From: Jeff Tarling
To: Jean Fraser
Date: 2/18/2016 8:40 AM
Subject: Public comment re Waterville Street Tree Fwd: Re: 31 Fore St. / comments
Attachments: Waterville Street.jpg

BOUNDARY & TOPOGRAPHIC SURVEY
ON
FORE ST. AND WATERVILLE ST, PORTLAND, MAINE
MADE FOR OWNER OF RECORD
PENINSULA PROPERTY DEVELOPMENT LLC
71 WEST ST., PORTLAND, ME 04102

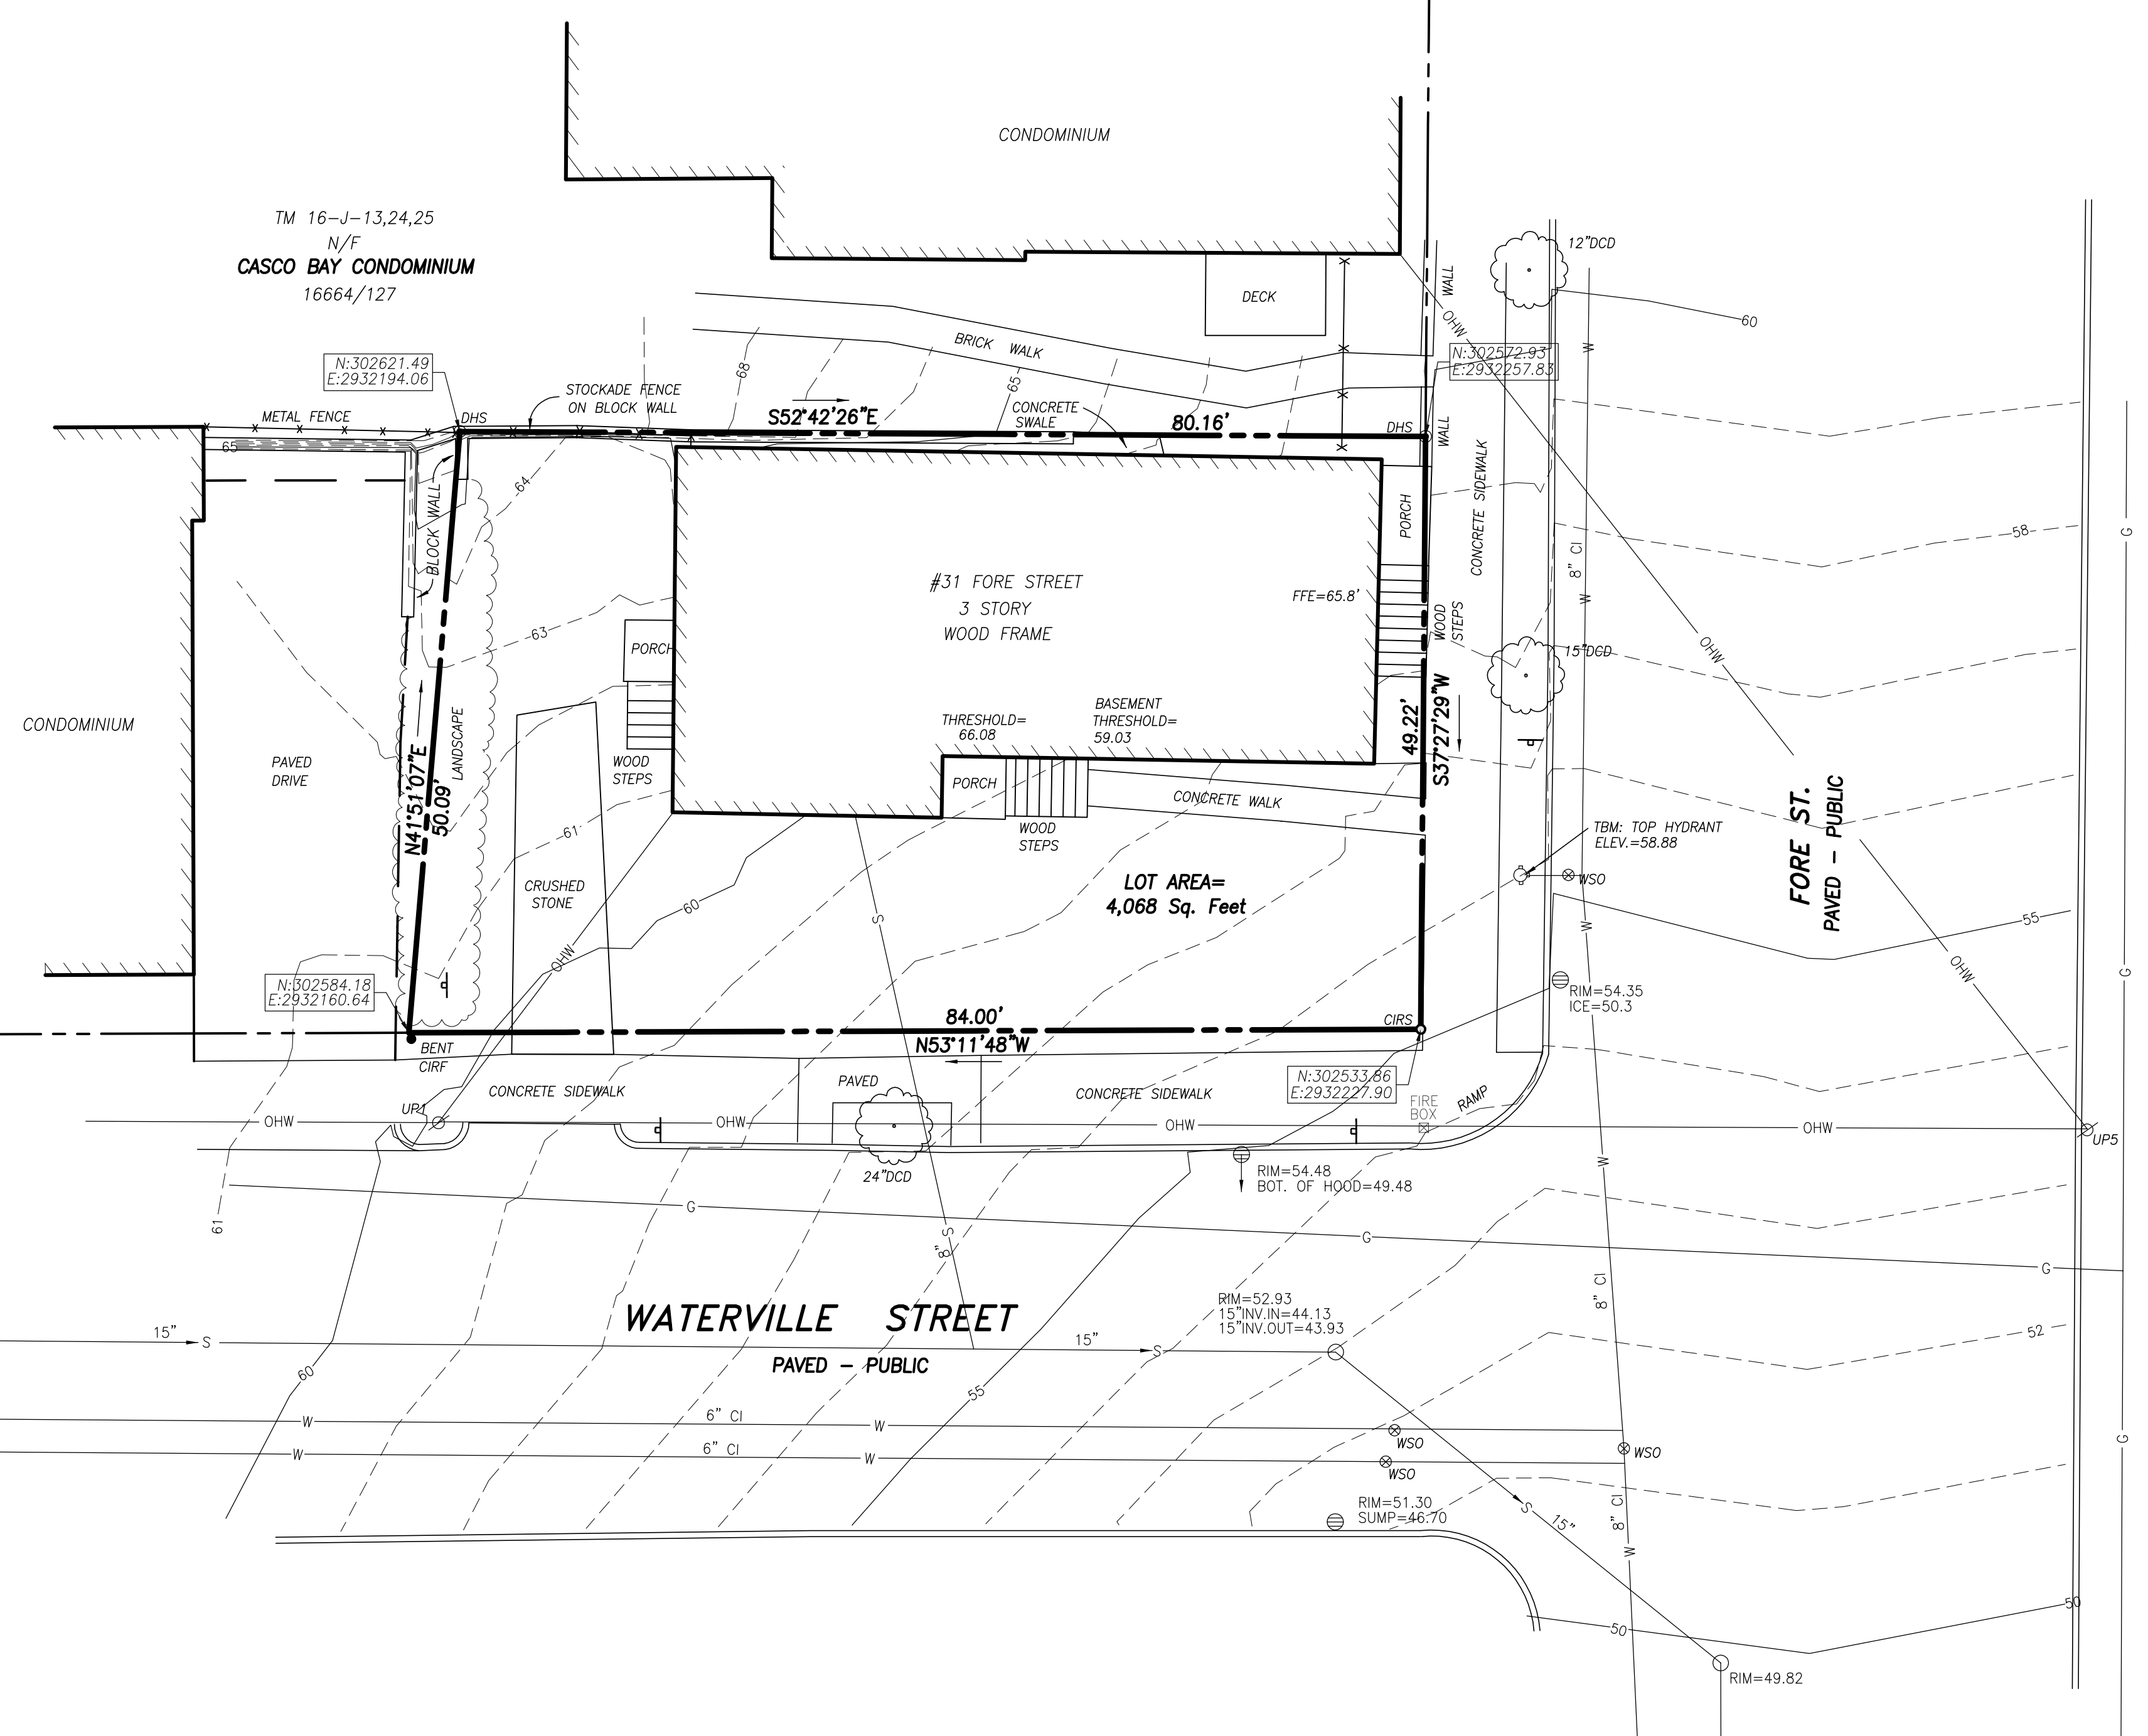
The nice existing Sweet Gum tree is near center of the driveway into the building.

"If" we could adjust the driveway into the under building parking we might have a tree-save option; past experience has few successful tree saves in these cases...
